REPORT on the IMPLICATIONS for EUROPEAN SITES

Proposed M3 Junction 9 Improvement

Planning Inspectorate Reference: TR010055

06 October 2023

DRAWING TITLE
**GENERAL ARRANGEMENT PLANS
 APPP REGULATION 5(2)(c)
 SHEET 5 OF 10
 DOCUMENT REFERENCE: 2.5**

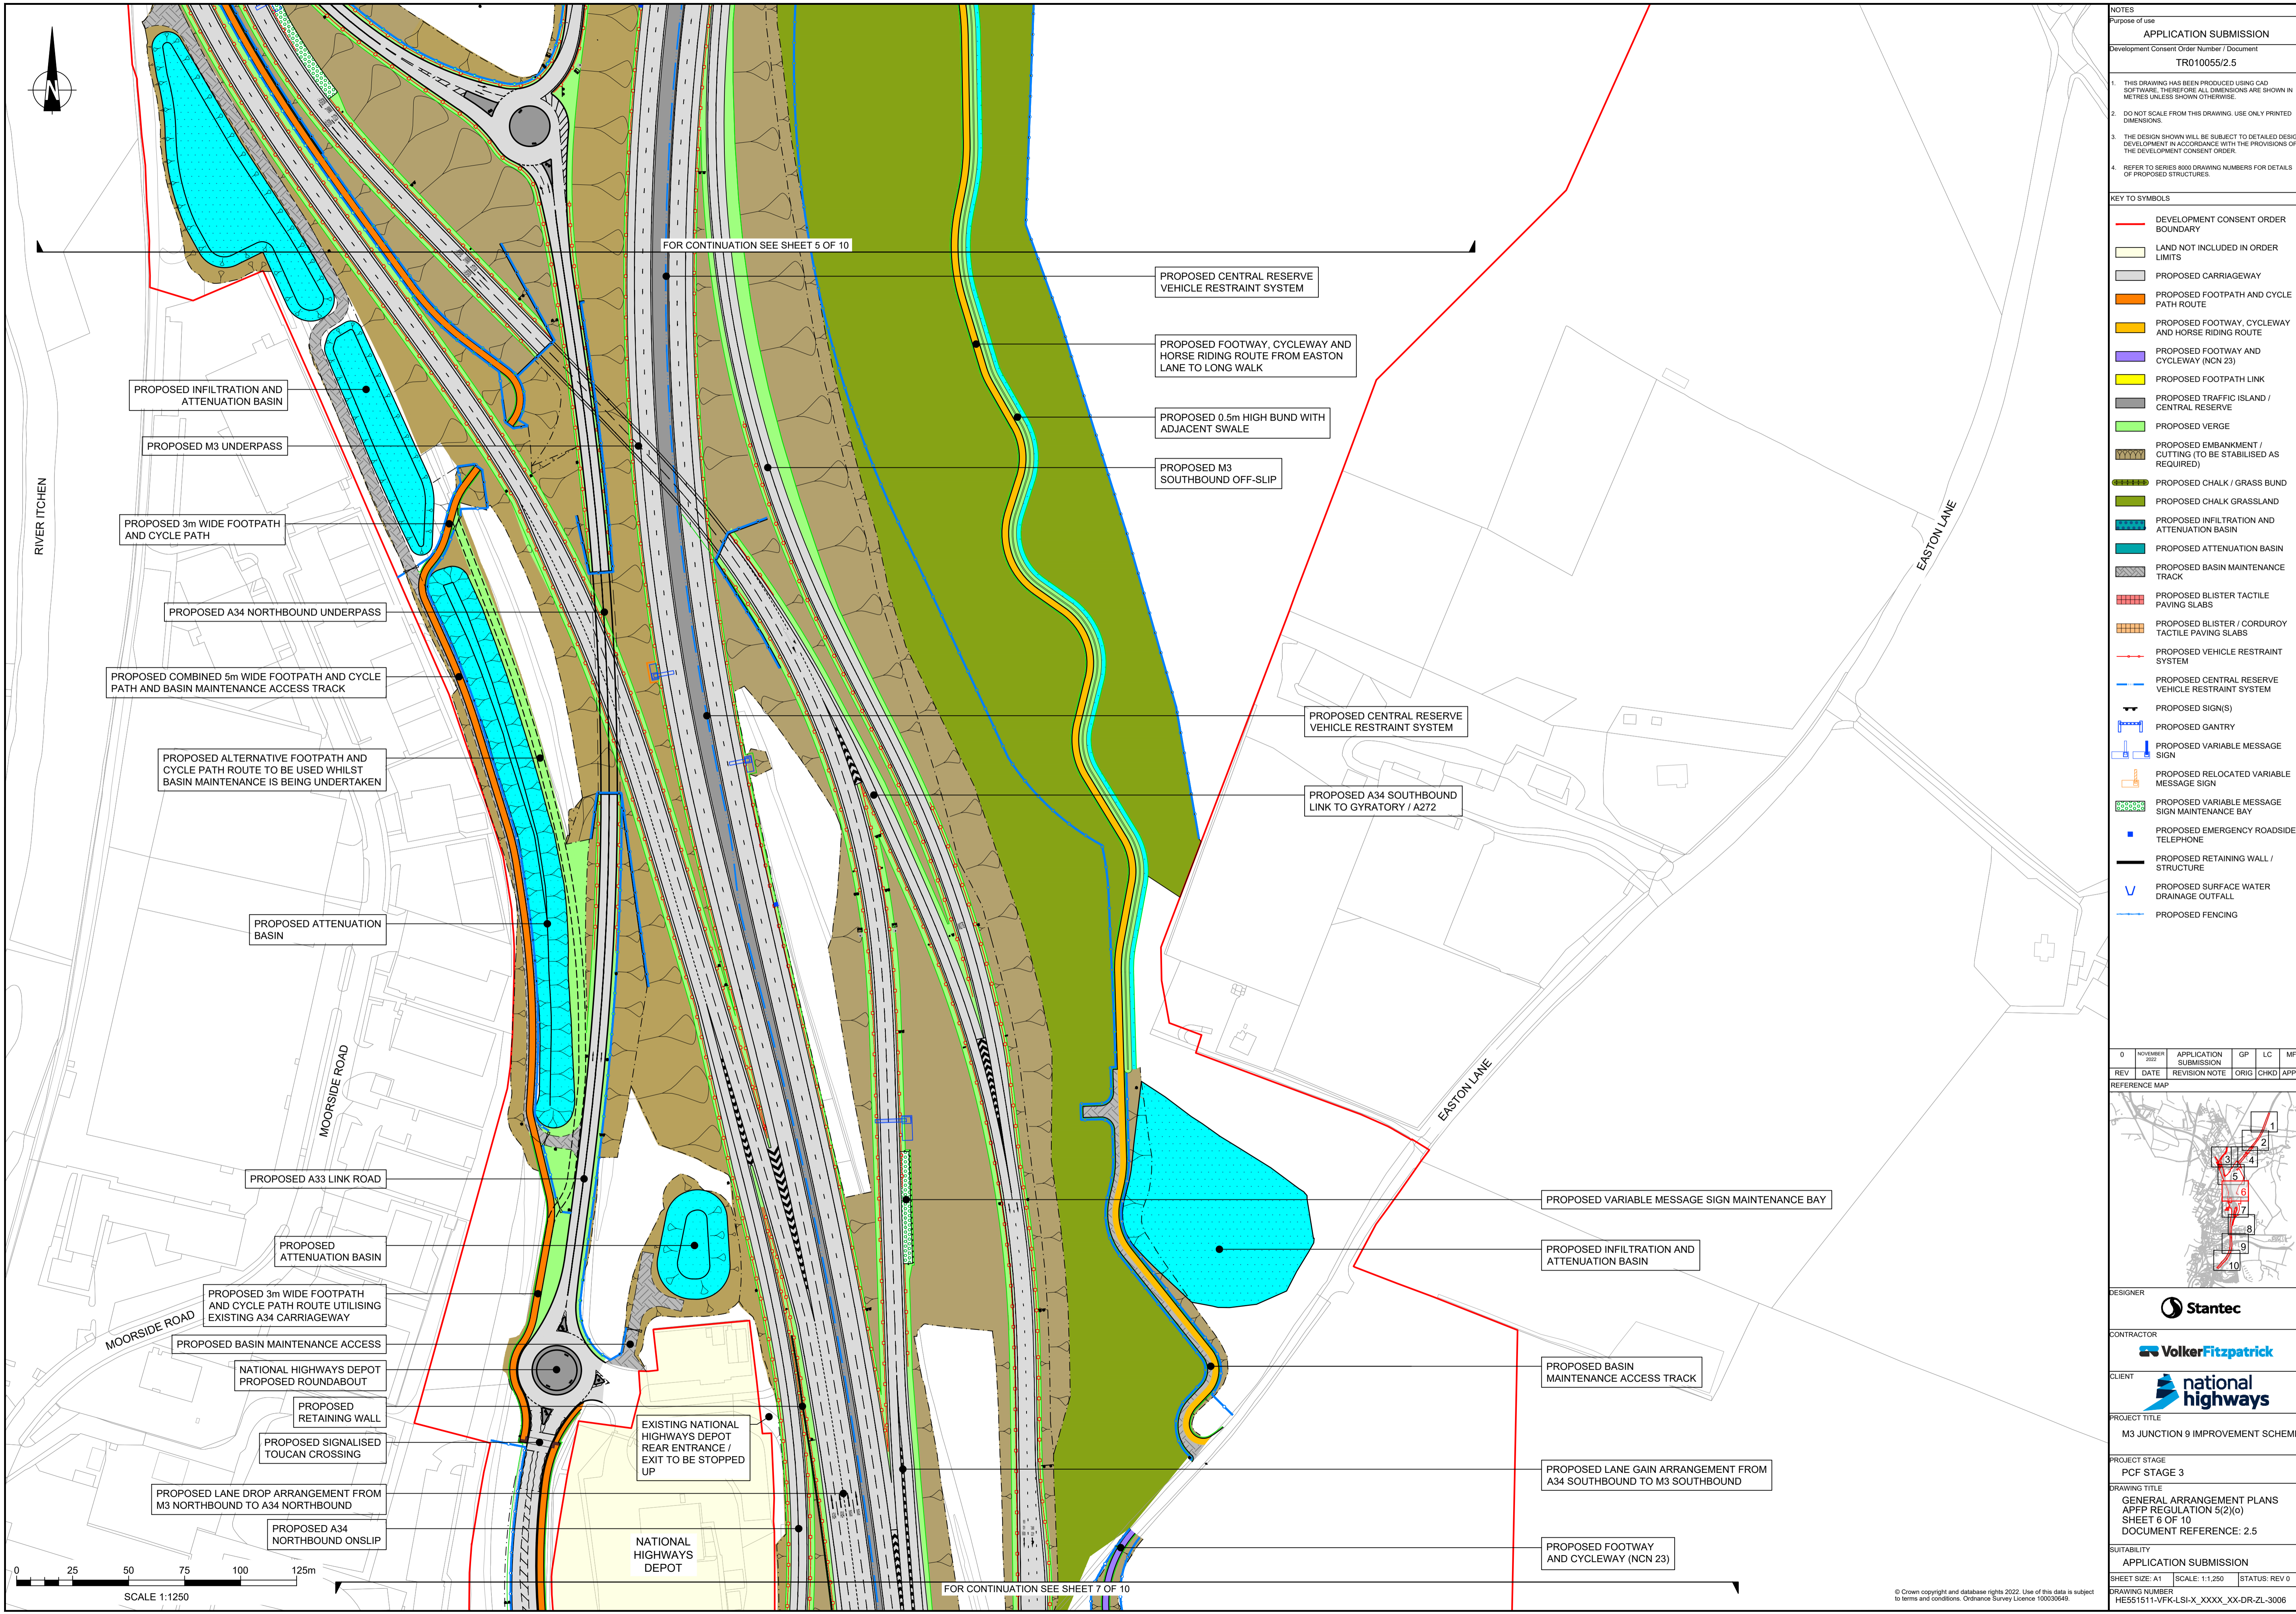
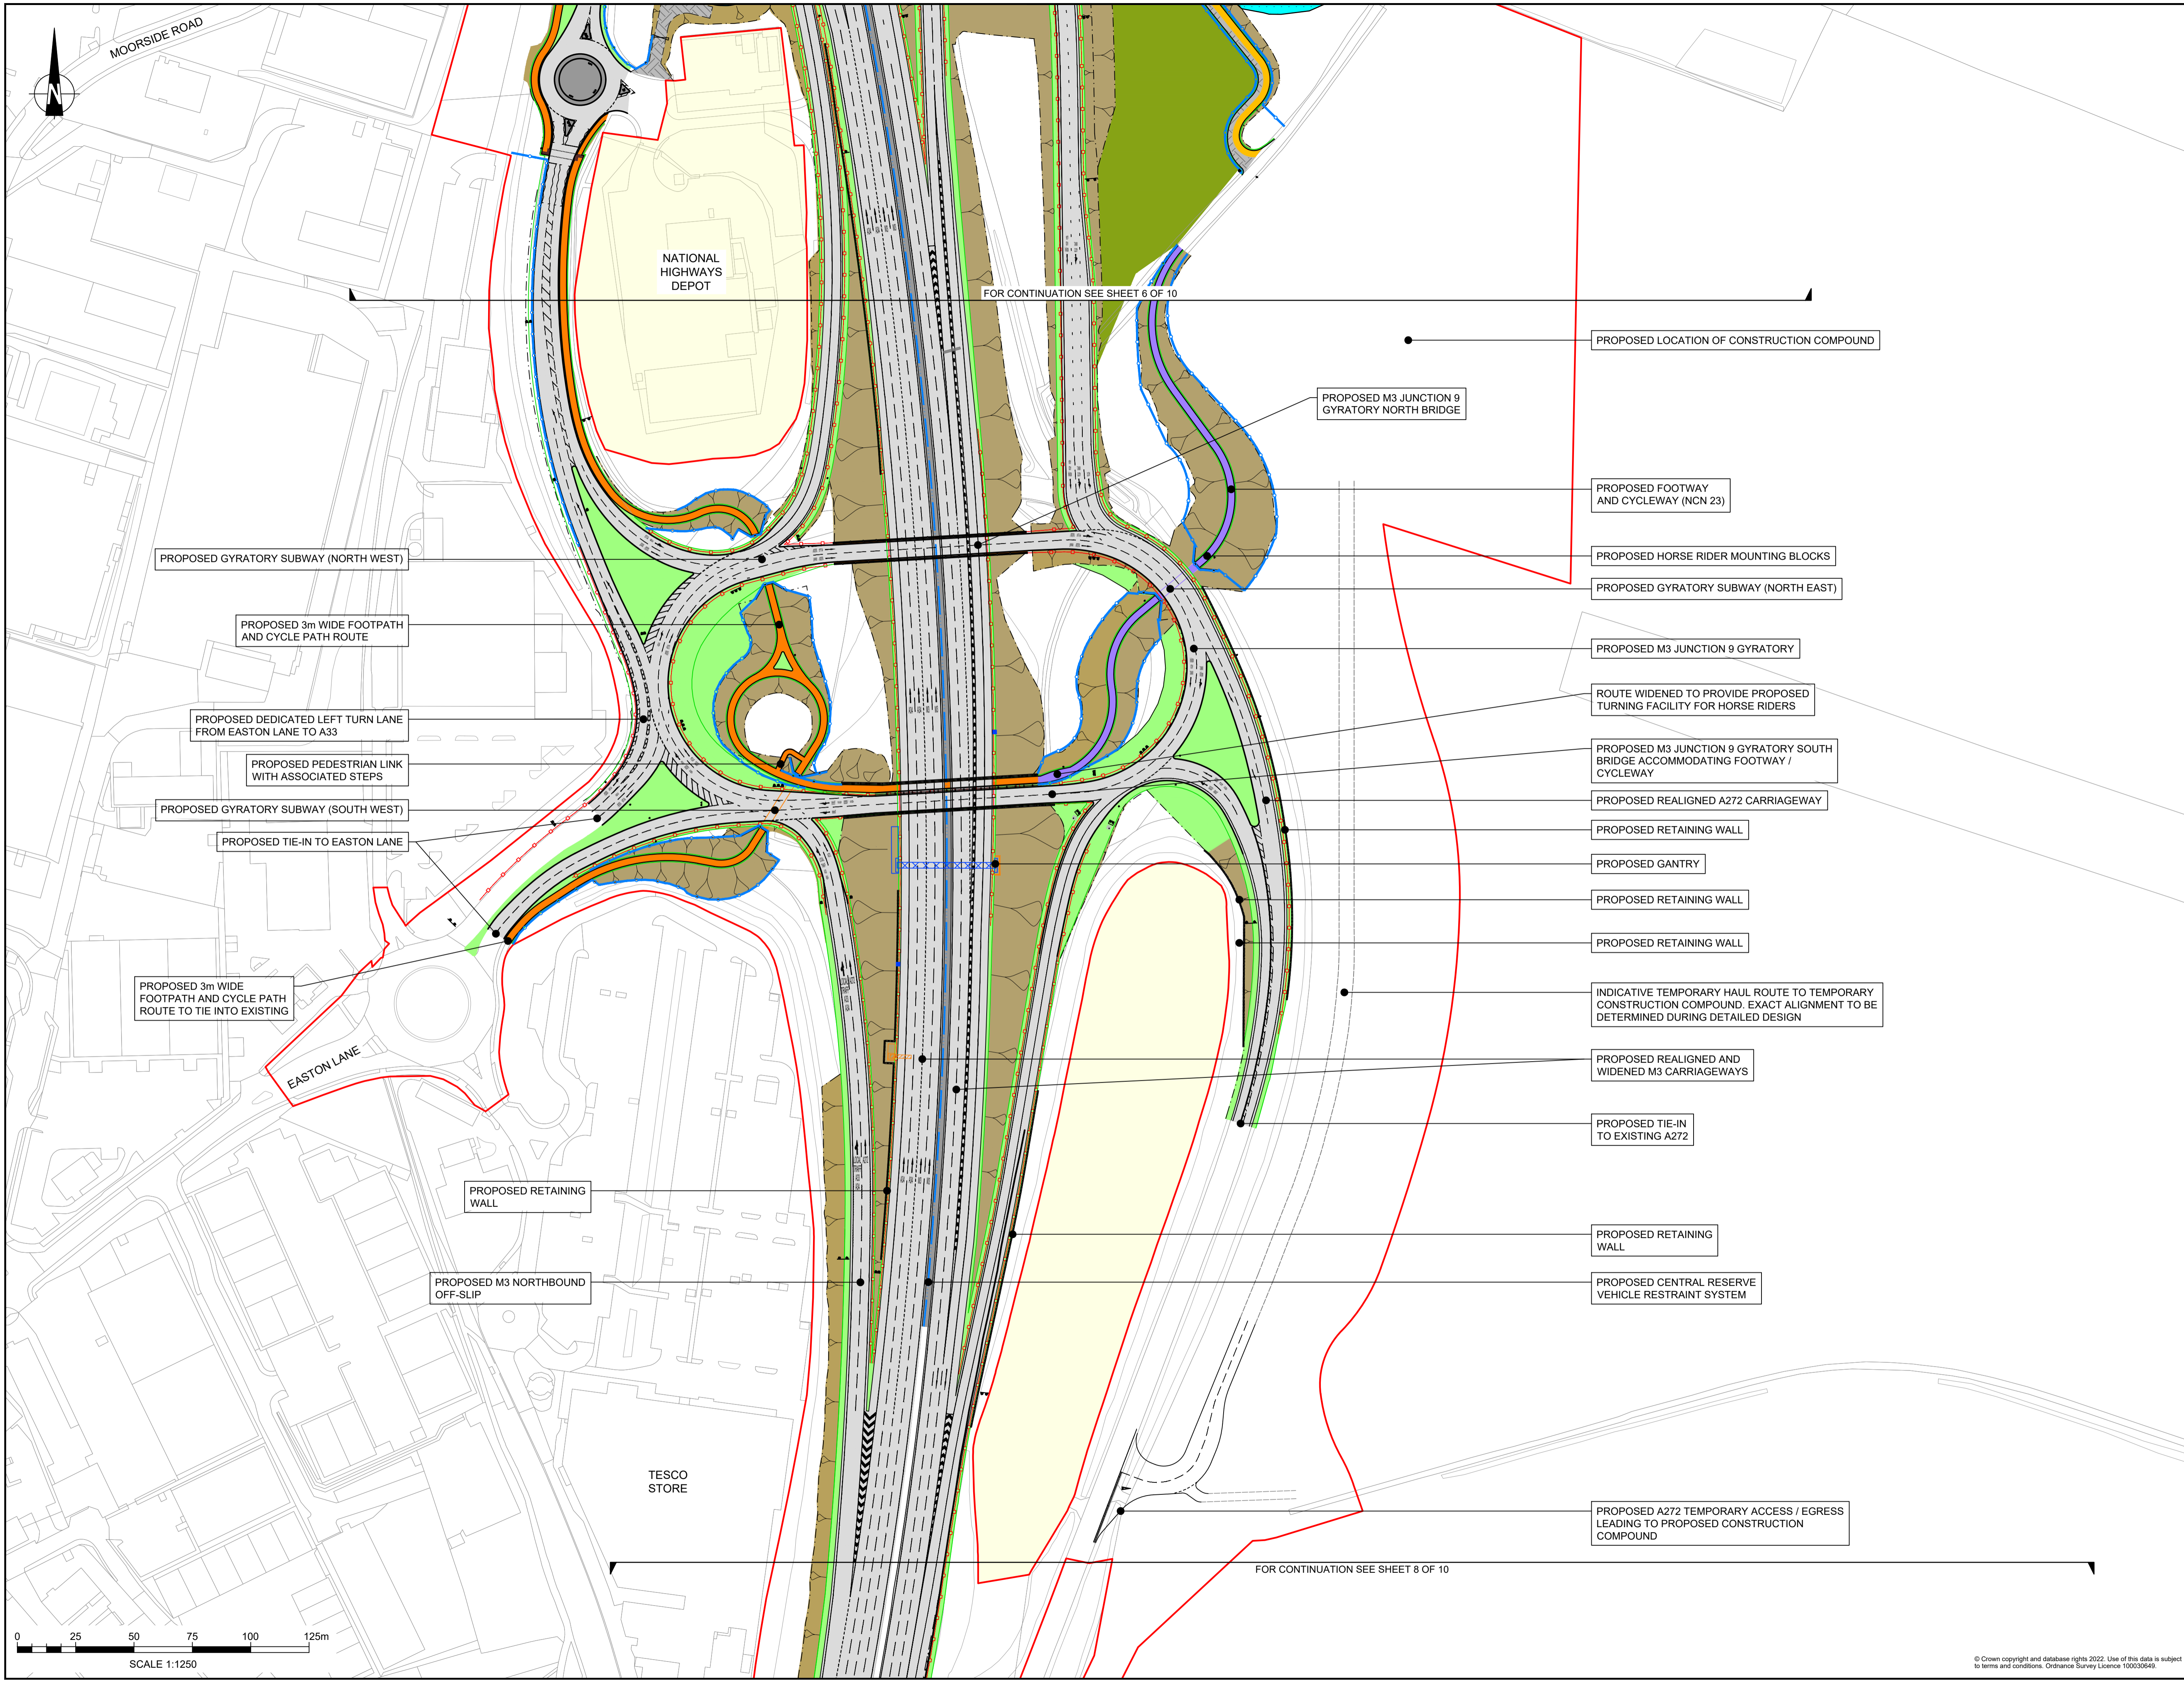
3.1.3	Disturbance effects to otter	<p>The HRA proposes the use of pedestrian fencing to avoid disturbance to otter (paragraph 4.9.3). The Applicant was asked to clarify how this mitigation had been secured (Q5.1.21 of [PD-008]). The Applicant clarified [REP2-051] that the proposed fencing was shown on the General</p>	n/a – matter resolved

Arrangement Plans (2.5, APP-009), and that further details of the fencing will be provided within the Landscape and Ecological Management Plan (LEMP) to be secured through Requirement 3 of the draft DCO in agreement with statutory consultees.
